DECISION DELEGATED TO DEVELOPMENT MANAGER

Application No: H18-0120-19 **Applicant:** Loyd Homes Ltd
Proposal: Sustainable development of up to 70 dwellings
Location: Land North: Withington Street Sutton Bridge Spalding
Terminal Date: 6th July 2019

Proposed Illustrative Block Plan

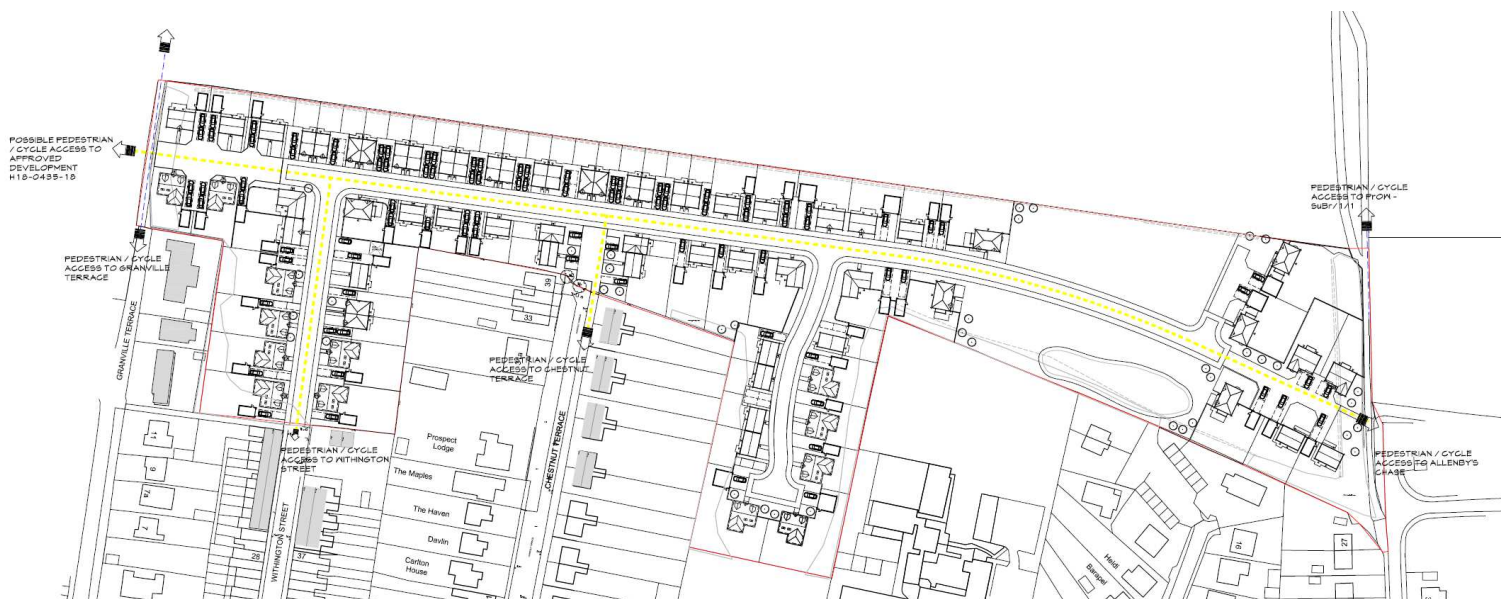
Whilst not forming part of the proposal, the indicative layout does give rise to a number of concerns. The need to significantly raise floor levels would lead to a significant overlooking impact on existing that sit adjacent to the site. Whilst in terms of density the design is comparable to that of the adjacent housing stock, the height of the new dwellings would present as visually discordant and therefore be detrimental to the built character of the area as a whole.

Policy 3 has a number of criteria where the submitted proposal would generate concerns. The indicative layout would require the prominent location of refuse collection points to the detriment of the built character. In additions, the need to significantly raise floor levels to address flood risk matters would lead to overlooking / overshadowing concerns as well as visually jarring development, immediately adjacent existing housing stock.
